ADDENDUM STATEMENT OF HERITAGE IMPACT FOR MODIFICATION APPLICATION (SSD-9671): YOUNG HIGH SCHOOL LIBRARY AND JOINT-USE COMMUNITY FACILITY

Prepared by Dr Rebecca Parkes, 29 November 2021.

This document has been prepared by Lantern Heritage Pty Ltd on behalf of School Infrastructure New South Wales (SINSW). It aims to address Heritage Council of NSW comments received via Department of Planning, Industry and Environment (DPIE) as a Request for Information (RFI). In particular, it provides a review of potential impacts to heritage significance (including archaeological resources) that may occur as a result of the proposed modifications outlined in the *SECTION 4.55(1A) MODIFICATION APPLICATION (SSD-9671) YOUNG HIGH SCHOOL LIBRARY AND JOINT_USE COMMUNITY FACILITY* prepared by Ethos Urban.

**Figure 2** Proposed Tree Protection and Removal Plan for Carrington Park (modifications are clouded)

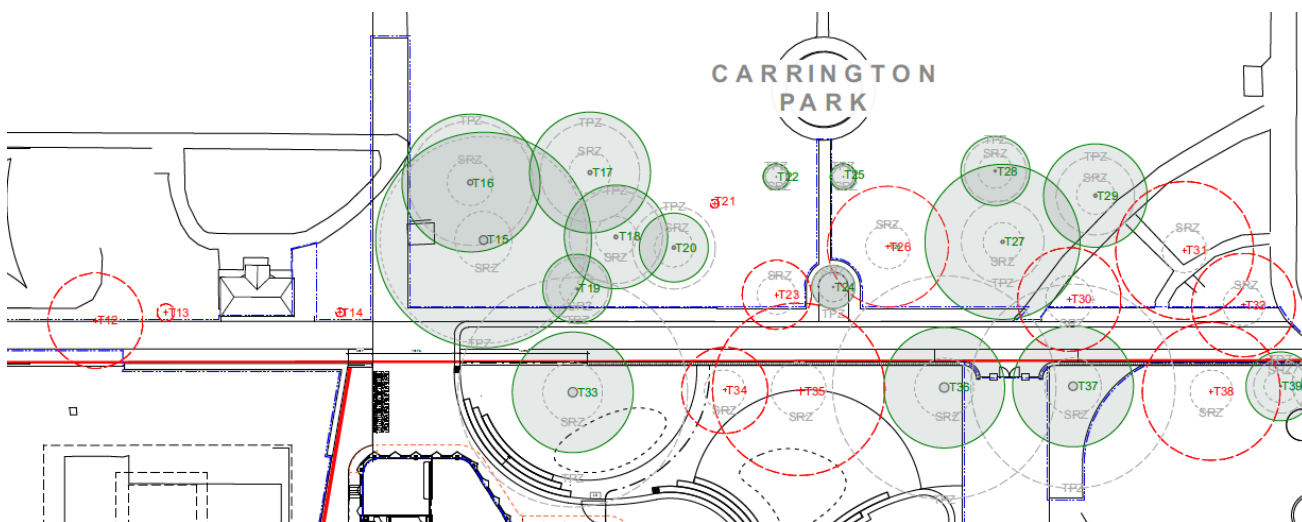
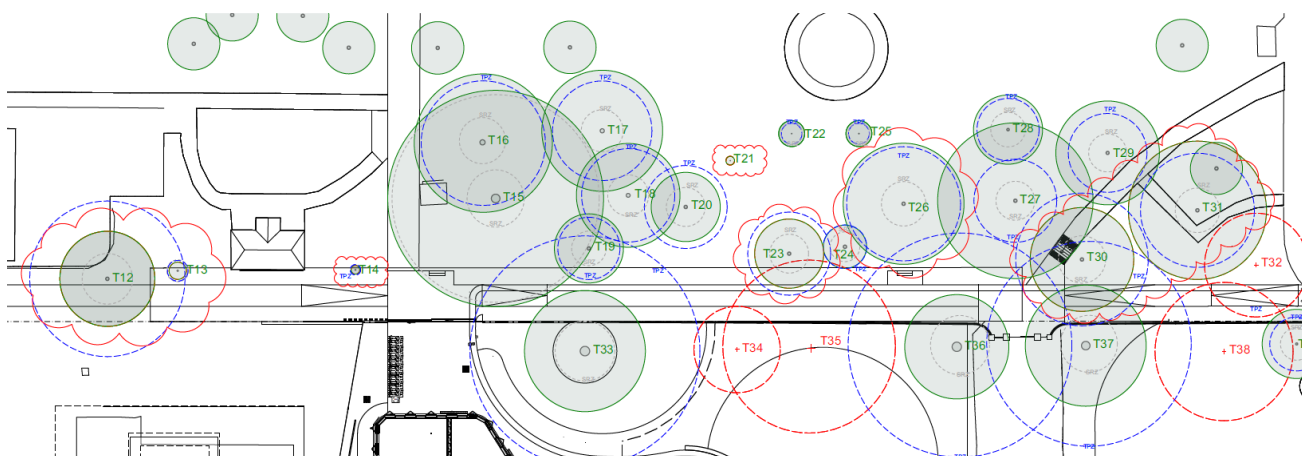
Modification	Positive Outcome for Heritage Significance	Potential Impacts on Heritage Significance	Design Inquiry and Justification	OUTCOME
<p>Tree retention</p> <p>Tree 12 - Grevillea Robusta Silky Oak; Tree 13 - Ulmus Glabra Lutescens Golden Elm; Tree 14 - Ulmus Glabra Lutescens Golden Elm; Tree 21 - Ulmus Glabra Lutescens Golden Elm; Tree 23 – Picea Pungens Blue Spruce; Tree 26 - Cedrus Deodara Himalayan Cedar; Tree 30 - Eucalyptus Cinerea - Argyle Apple; And Tree 31 - Cedrus Deodara Himalayan Cedar.</p>	<p>Retention of the public garden landscape, particularly established trees.</p> <p>Reduces ground disturbance and thus avoids potential impacts to archaeological deposits associated with the Lambing Flat Riots.</p>	<p>Tree retention reduces/ impedes sight lines to and from the locally significant Courthouse building.</p> <p>Root systems of the retained trees may increase the bioturbation (disturbance) of any adjacent archaeological deposits. However, given that the deposits within Carrington Park are most likely to comprise artefactual evidence of the Riots (e.g. firearms related artefacts), rather than structural elements or stratified archaeological deposits, the potential disturbance is unlikely to have a substantial impact on the heritage significance of any relics that may be present.</p>	<p>Refer to the HIS (EIS Appendix I - (=Section 6.2 Pages 34-37); supporting documentation for the proposed modifications to the SSDA.</p>	<p>The proposed modification will reduce the overall footprint of disturbance and is unlikely to result in any inadvertent impacts to archaeological resources of State significance that may be present below Carrington Park.</p> <p>The continuation of reduced sight lines to a locally significant structure has a negligible heritage impact.</p>

**Figure 3 Proposed path and pavement modifications in Carrington Park**

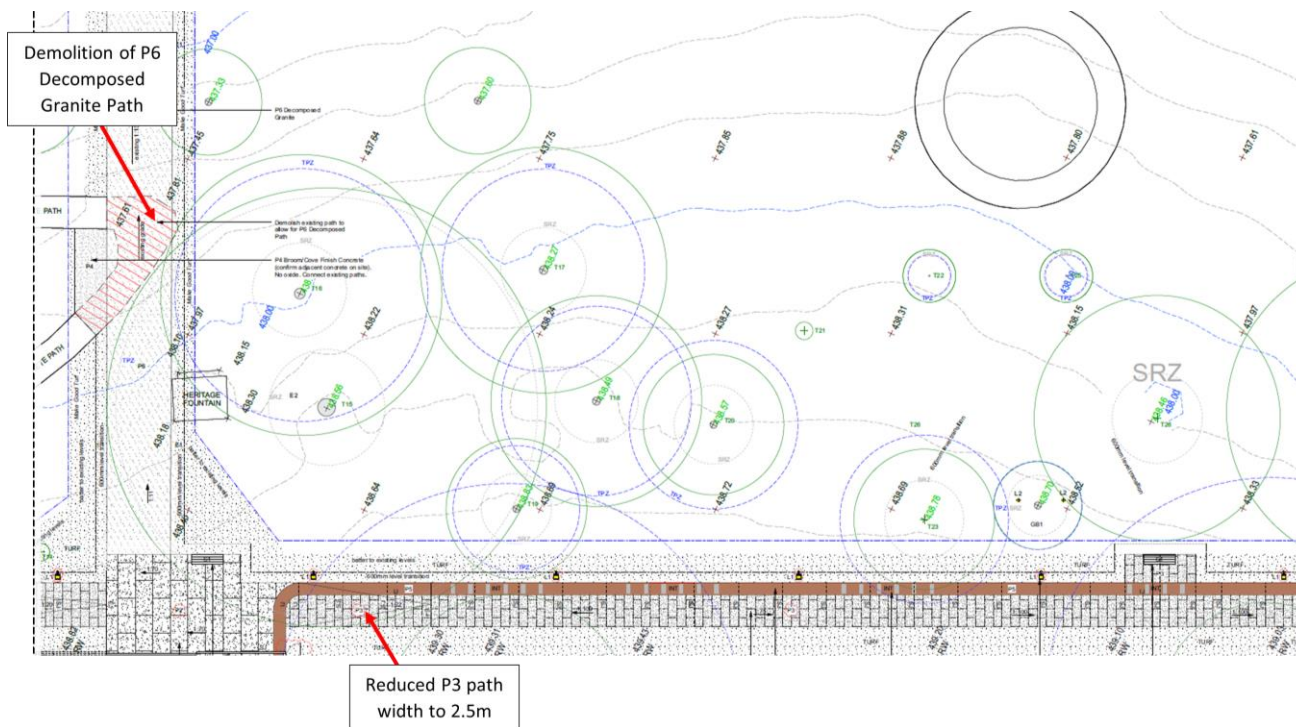
<p>Amendments to paving and paths</p>	<p>Removal of the decomposed granite path (P6) will assist with ensuring the health of the Reconciliation Tree.</p> <p>Reduction of the P3 path width reduces the extent of impacts</p>	<p>Depending on the method of removal, potential exists for impacts to subsurface deposits that may contain artefactual evidence of the Lambing Flat Riots.</p>	<p>Refer to the HIS (EIS Appendix I - (=Section 6.2 Pages 34-37); supporting documentation for the proposed modifications to the SSDA.</p>	<p>The proposed modification will reduce the overall footprint of disturbance and is unlikely to result in any inadvertent impacts to archaeological resources of</p>

**Figure 7 Proposed amended landscape design for internal school quadrangle**

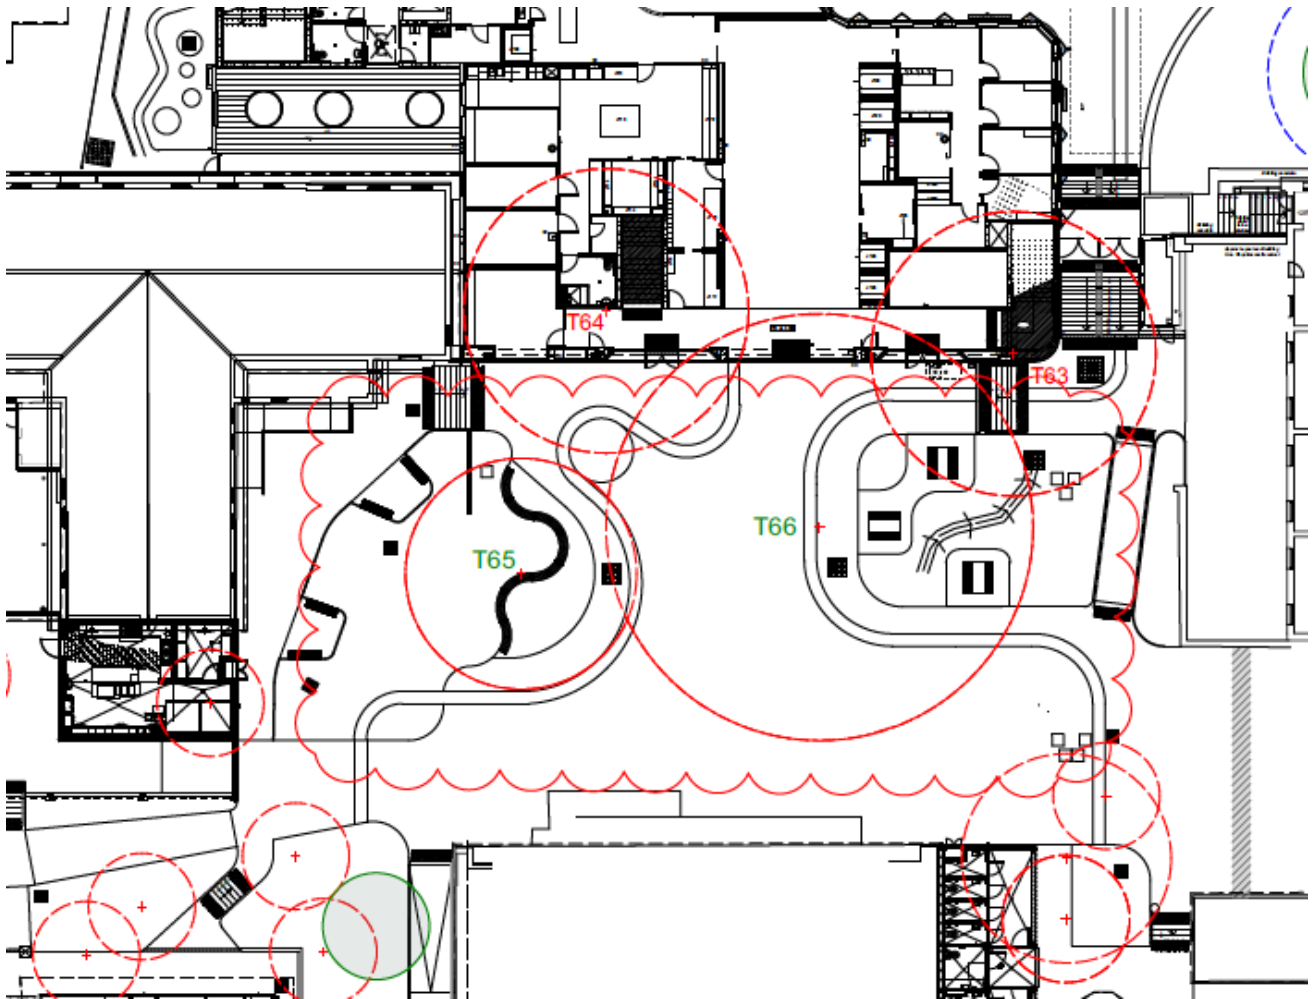
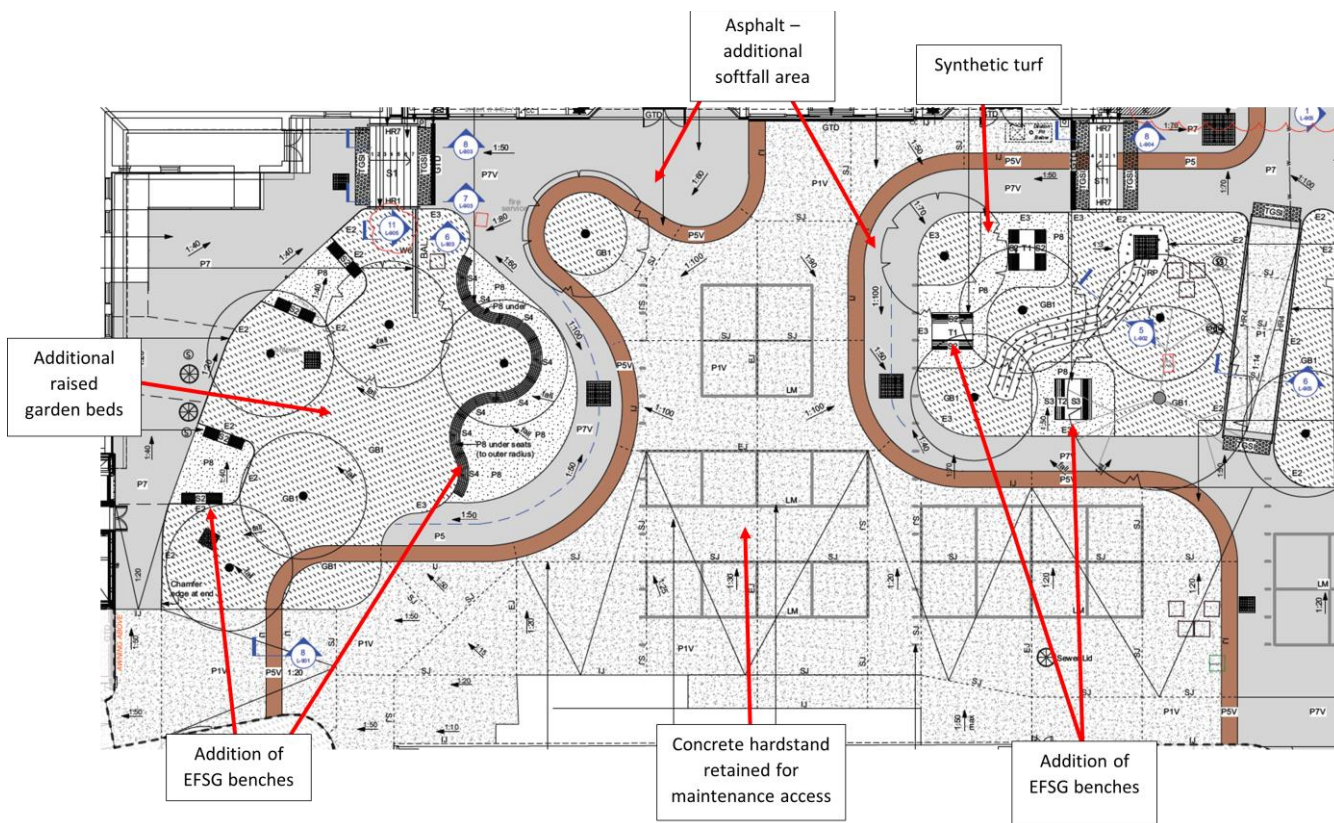
Modification	Positive Outcome for Heritage Significance	Potential Impacts on Heritage Significance	Design Inquiry and Justification	OUTCOME
	<p>within Carrington Park. This means there is an overall net decrease in impacts to potential archaeological resources within this area.</p>			<p>State significance that may be present below Carrington Park.</p> <p>Potential for disturbance from removal of the gravel path can be mitigated through implementation of manual methods for path removal and/or monitoring by an archaeologist.</p>
<p>Quadrangle modifications</p>	<p>The removal of the two trees within the quadrangle area will be conducted without physical disturbance to potential archaeological deposits of State significance. The root systems of the trees will be left in situ. The area will be built up without any disturbance to subsurface deposits likely to contain State significant relics. This will in turn remove the potential for the root systems of these two trees to cause any further disturbance to archaeological deposits beneath the quadrangle.</p> <p>The proposed changes to surfaces within the quadrangle will not have any direct impacts on any underlying archaeological deposits (i.e., there will be no ground disturbance beyond existing layers</p>	<p>Removal of the root systems of the trees would have potential to result in disturbance to archaeological deposits that are likely to be of State significance. As such, the root systems will be left intact.</p> <p>The increase in garden beds, and particularly the addition of semi-mature trees has the potential to impact subsurface archaeological deposits below the quadrangle. However, it is understood that these planting will be conducted without disturbing existing deposits (i.e. the plantings will be built up). While there is minor long term potential for bioturbation (disturbance) to archaeological deposits from new tree roots, the existing fill and new garden beds will limit any such disturbance.</p>	<p>Refer to the HIS (EIS Appendix I - (=Section 6.2 Pages 34-37); supporting documentation for the proposed modifications to the SSDA.</p>	<p>There are no direct impacts to existing subsurface deposits proposed by this modification.</p> <p>The proposed modification will actually reduce future potential for impacts to State significant archaeological resources below the existing quadrangle.</p>
